My reference 20054163

EN010147 Botley West Solar Farm Have Your Say Commentary

Appendix “A”

**Illustrative Masterplan**  
**Figure 2.1A**  
 Northern Site Area 1 of 2

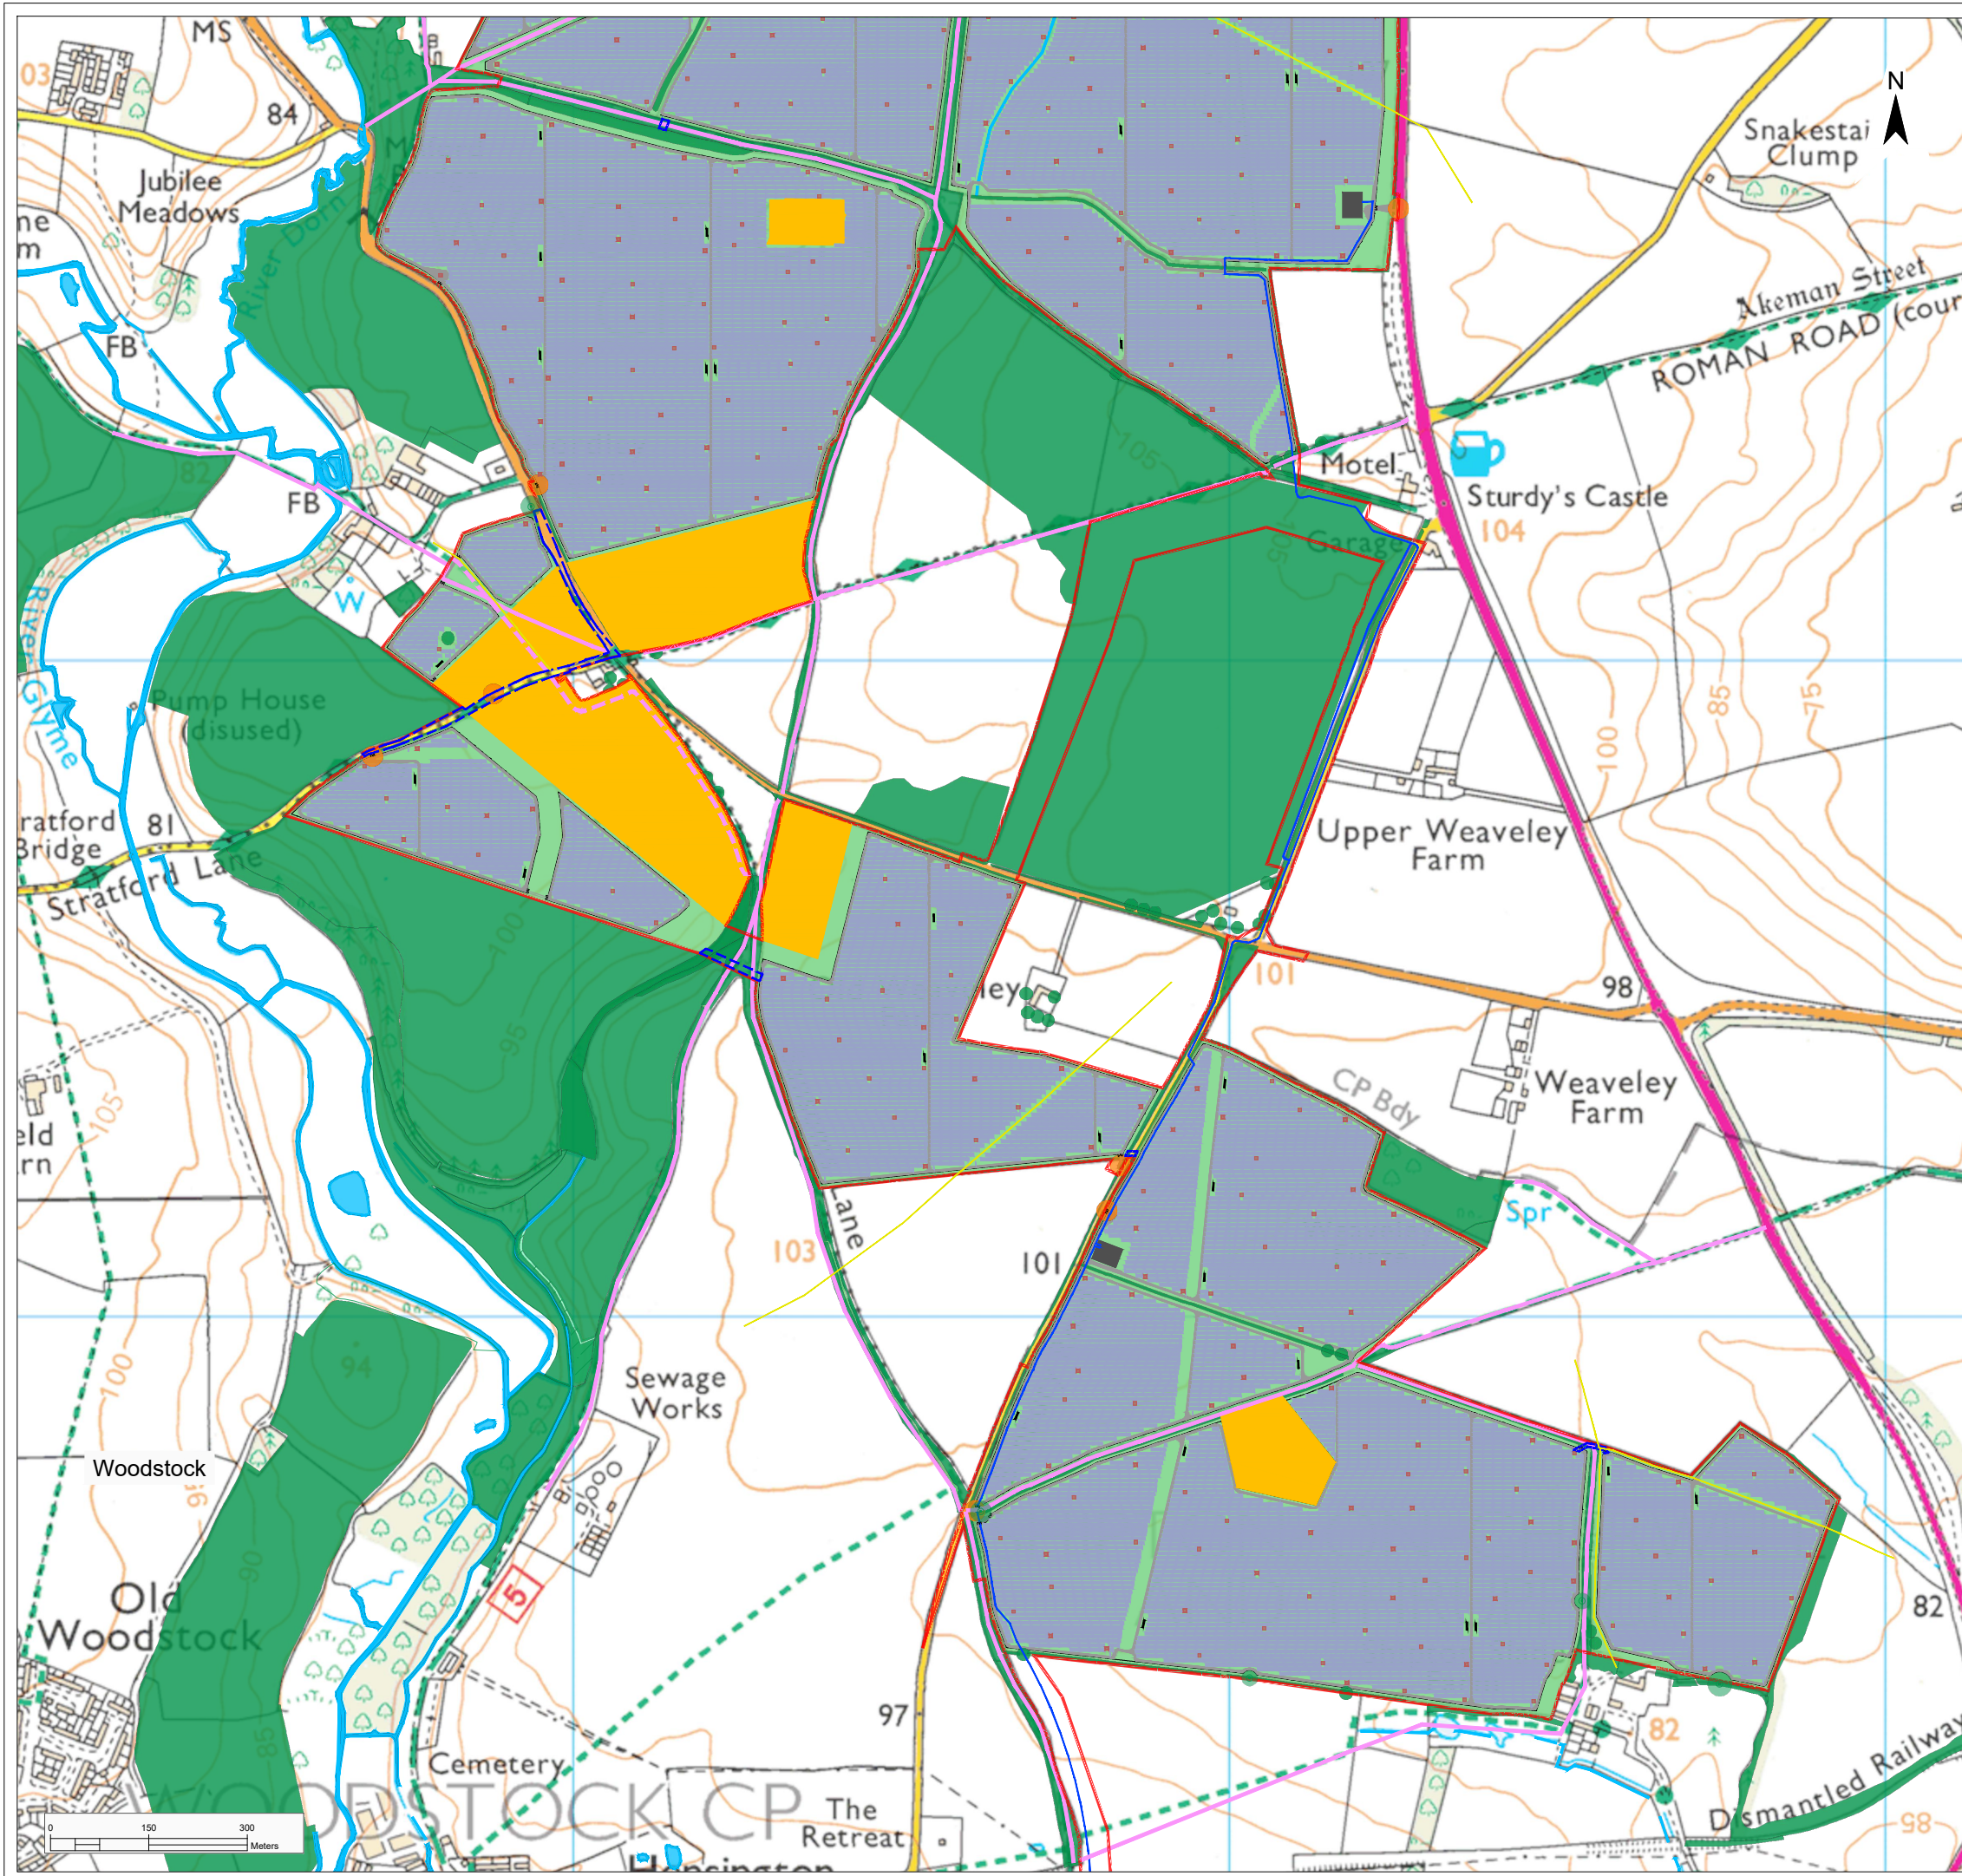
- National Cycle Route 5 Reading to Stratford.** The National Cycle Route No. 5 (NCN 5) (Def Map Ref 416/11/10-40, 379/19/10-20, and 413/5/10) is identified by the applicant as a national strategic cycle route. It runs through the heart of the Solar Farm proposals for approx. 3 miles (Drgs 2.1A and 2.1B). It was developed at the millennium (1999-2000) but is now in need of significant improvement. The applicant should be required to undertake a root and branch improvement to the structure and surface of this route between Upper Dornford and Woodstock. As a minimum this should include restoring the original width of the cycle path to a nominal 2.5m, the repair of the stone subgrade and a weather resistant top dressing.

**Illustrative Masterplan**  
**Figure 2.1B**  
 Northern Site Area 2 of 2

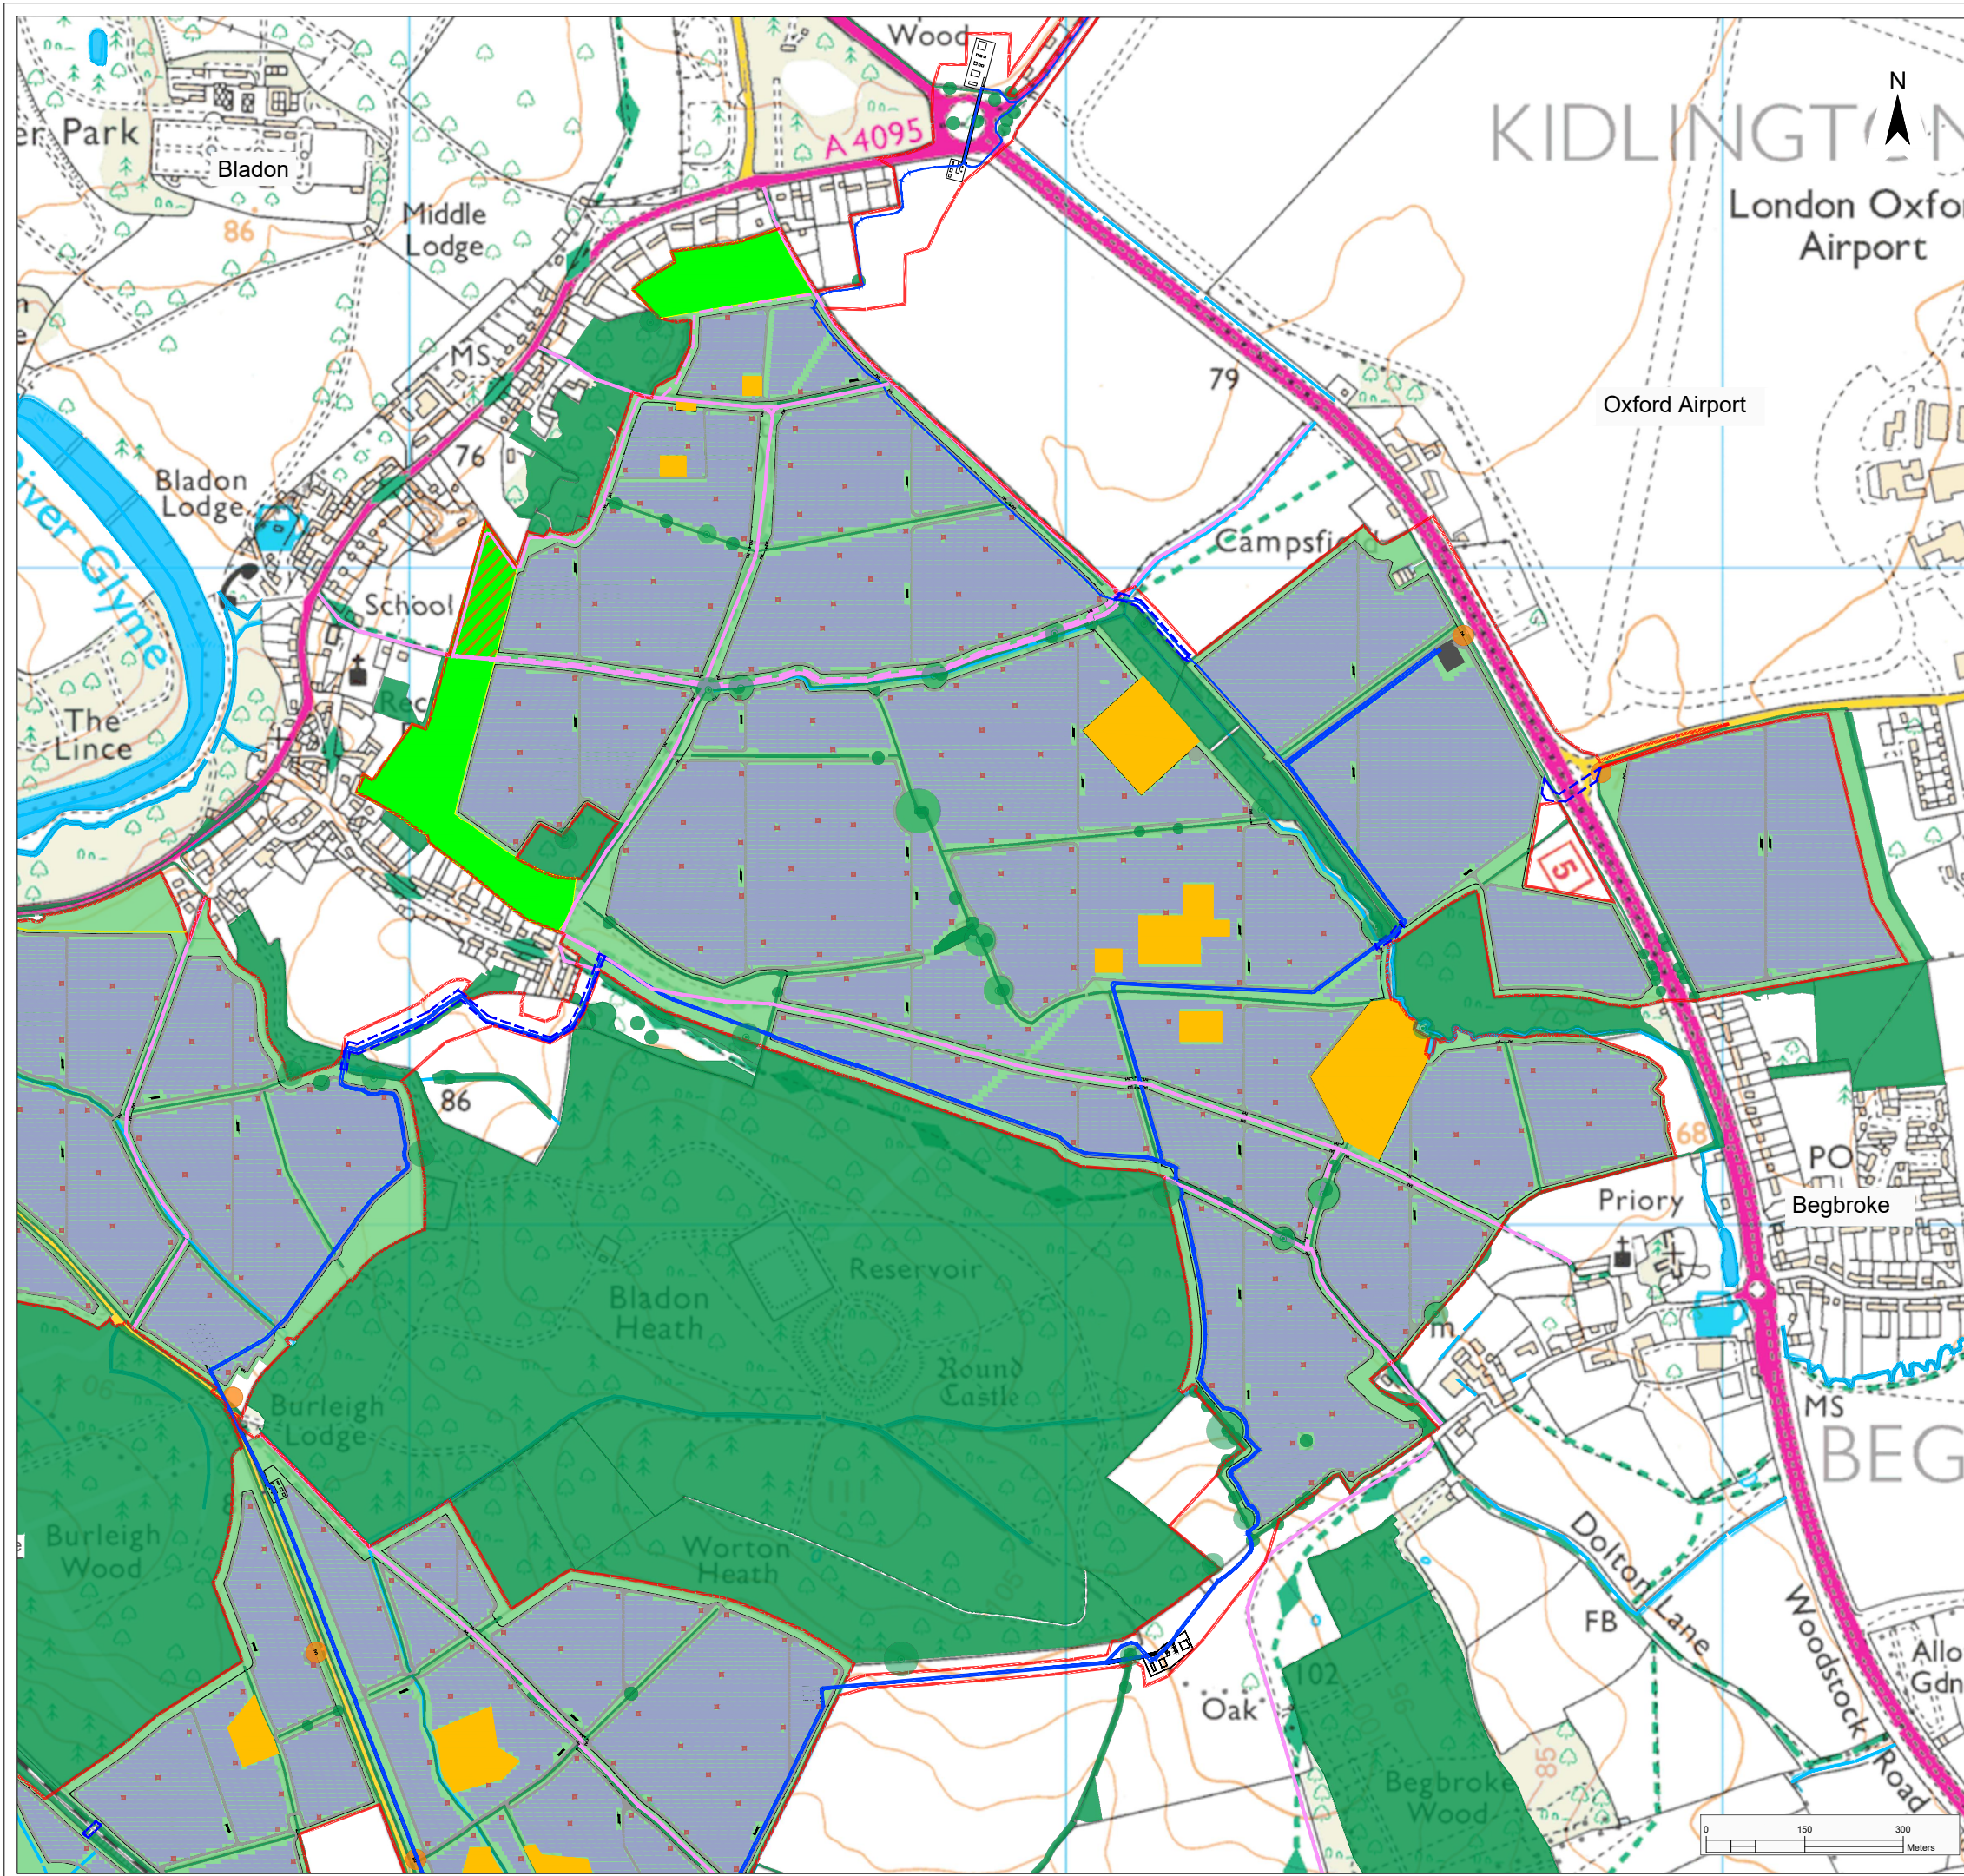
- Woodstock to Tackley and Wootton** The applicant should further be required to commit to upgrading the existing bridleway, (Def Map Ref 379/1/10-30) also known as the Oxfordshire Way long distance path, and which crosses the NCN 5. The section requiring improvement is between where it crosses the B4027 and

where it crosses the A4260 (shown in yellow on the **modified Drg. No 2.1B** here). This will provide active travel connections between Woodstock and Tackley, and Tackley and Wootton. Construction should be to a similar standard to NCN 5.

The applicant should also be required to work with the Highway and Traffic Authority (Oxfordshire County Council) and to provide a significant financial contribution towards safety improvements to four difficult crossing points for cyclists and pedestrians between Wootton, Tackley and Woodstock. These are indicated on the modified Drg No 2.1B with red circles. These locations are:-

- Crossing of The Oxfordshire Way bridleway with B4027
- Crossing of NCN 5 with B4027
- Crossing of B4027 with unnumbered Banbury Road Woodstock at Weaveley Farm
- Crossing of the unnumbered Banbury Road Woodstock and Oxfordshire Way with A4260 at Sturdy's Castle
